# CITY OF ALBUQUERQUE

July 18, 2025

**Re: Aloft Hotel Sunport**  
**1501 Aircraft Ave. SE**  
**Traffic Circulation Layout**  
Engineer's Stamp 7/16/2025 (M15D057)

Based upon the information provided in your submittal received 06-30-25, the above referenced plan cannot be approved for Building Permit until the following comments are addressed:

**HC PARKING DETAILS**  
1"=10'

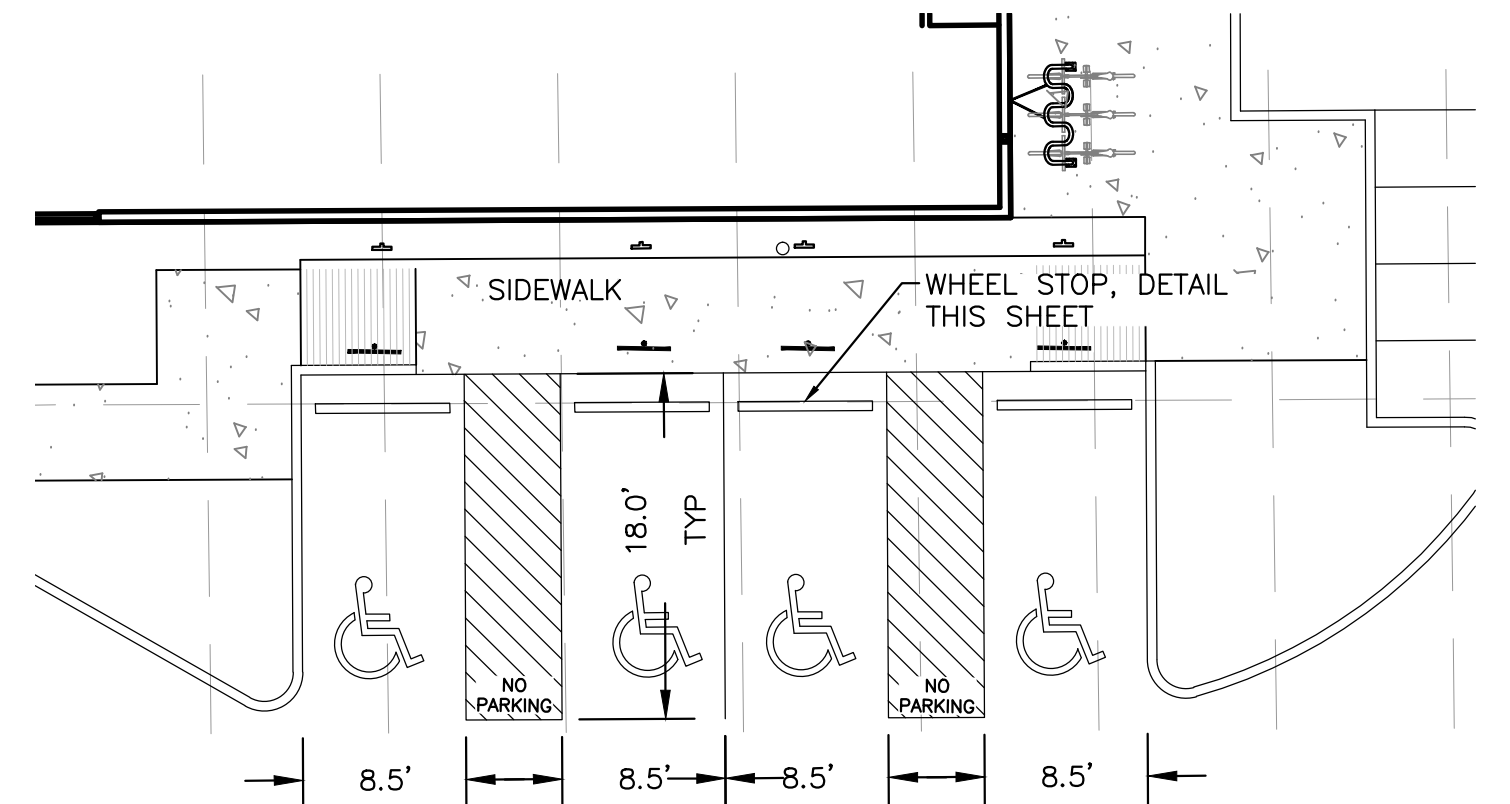
1. Please provide a minimum of 8.5ft with for ADA Accessible Parking.

1. ADA accessible parking shall be a minimum of 8.5 feet wide and 18 feet long. (See [TABLE 7.4.77](#) and [FIGURE 7.4.117](#).)
2. Accessible parking spaces shall be located closest to the building entrances and dispersed among the various types of parking facilities and uses.
